KITTITAS COUNTY COMMUNITY DEVELOPMENT SERVICES

June 20, 2018

Subject: Palomino Fields Division 1 Plat (LP-07-00031) – Scrivener Error Corrections – Request for Additional information.

Surveyed by LMH	Date 04-16	Scale 1" = 200'
Drawn by Tml/FCS	Date 05-18	Sheet 1 of 5
Checked by FCS	Date 06-18	Project No. 15169

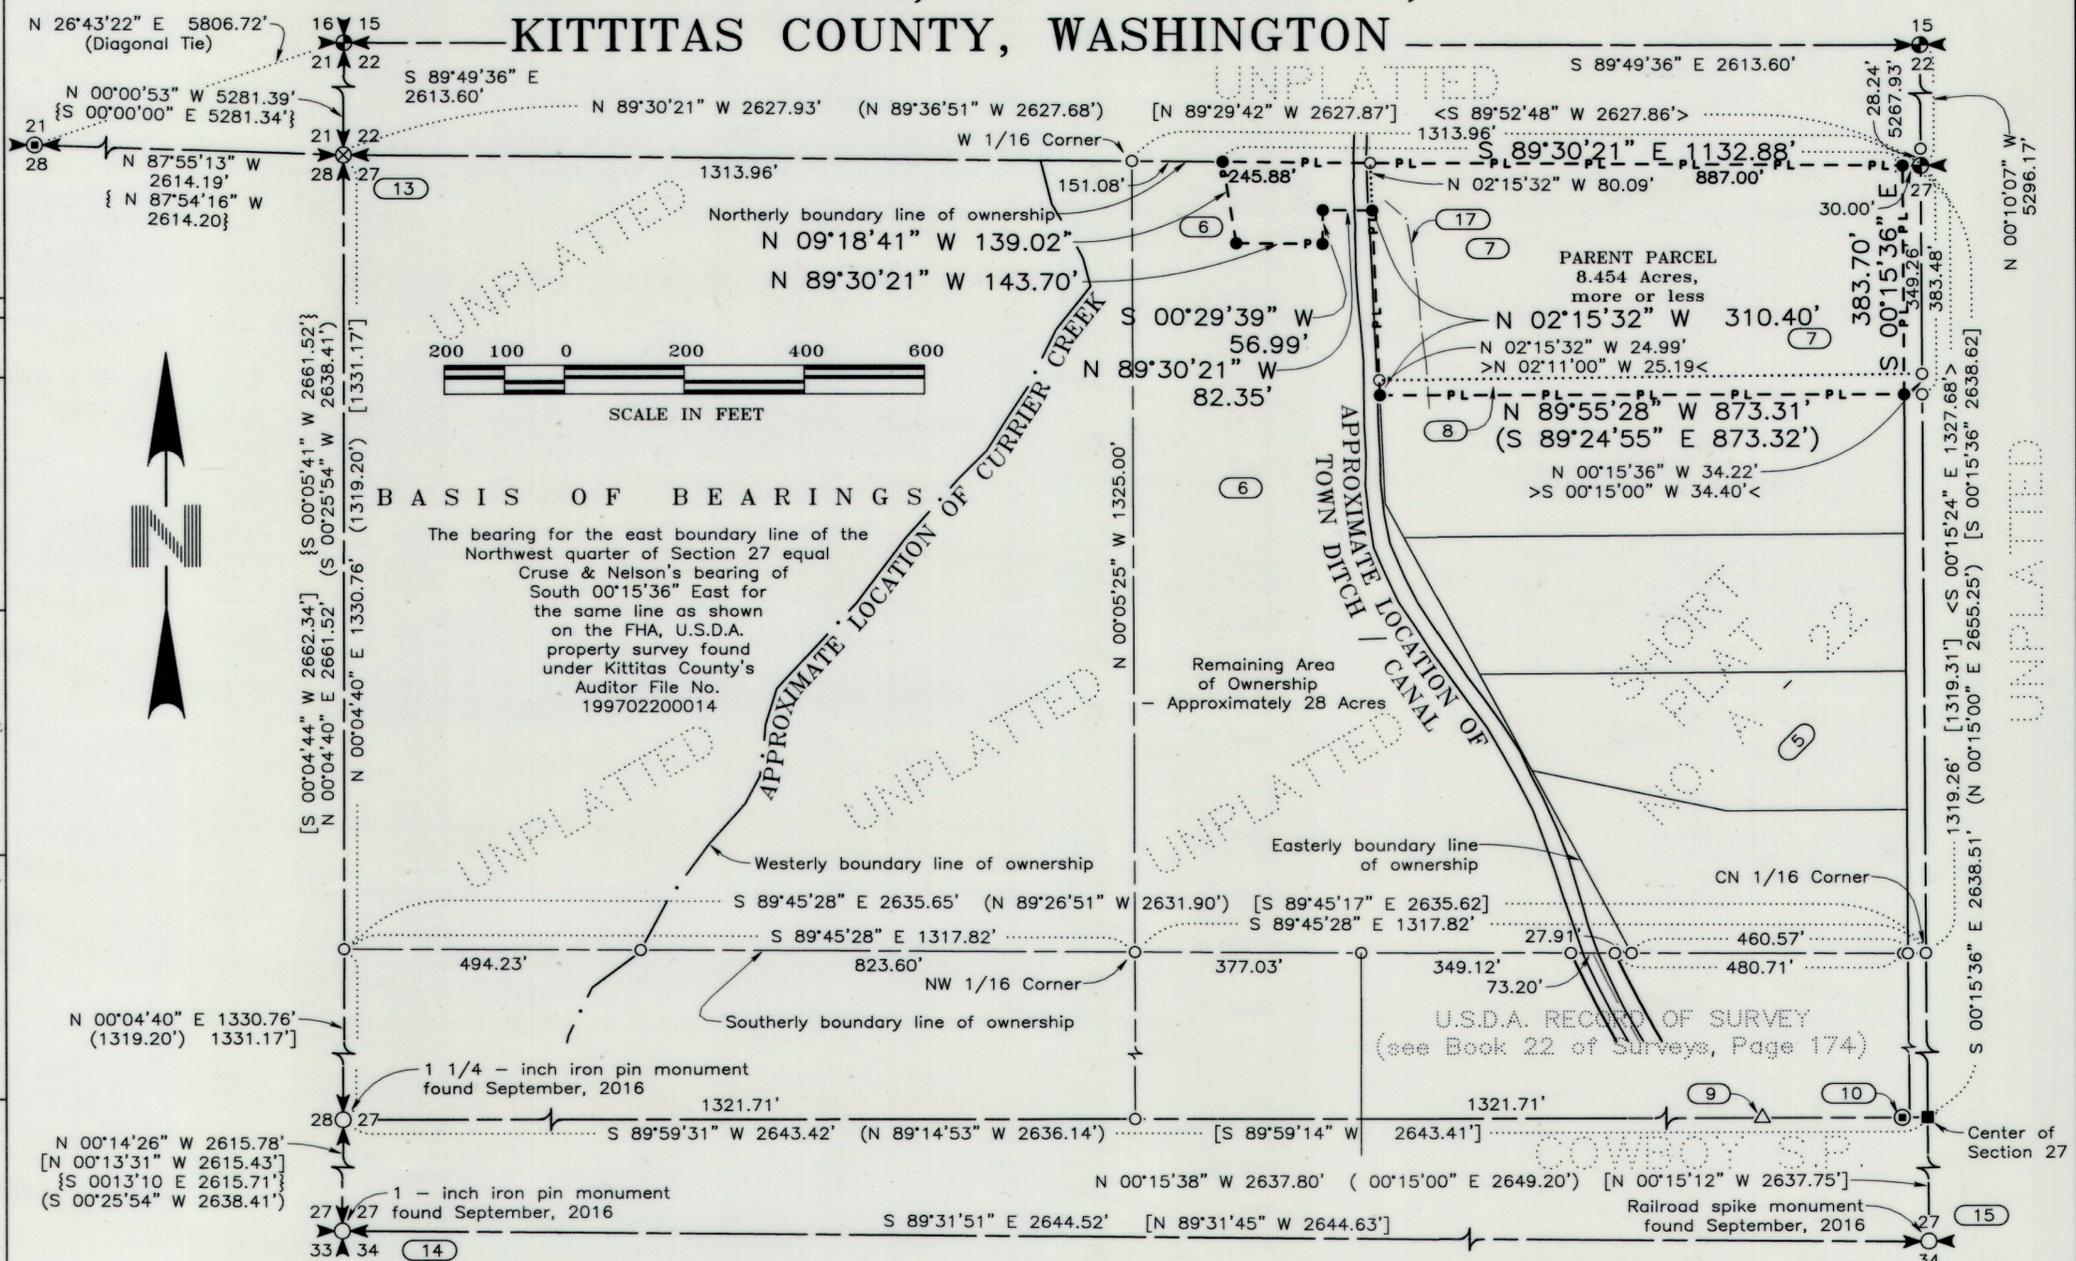
- The title of this plat shall be “**Palomino Fields Plat – Division 1**”. This was indicated in the above mentioned email on May 1st.
- Sheet 1 and Sheet 2 shall show the wetland boundary with associated plat note. This is not provided on the most recent set of mylar, however it was included on the set reviewed by the county in April 2018.
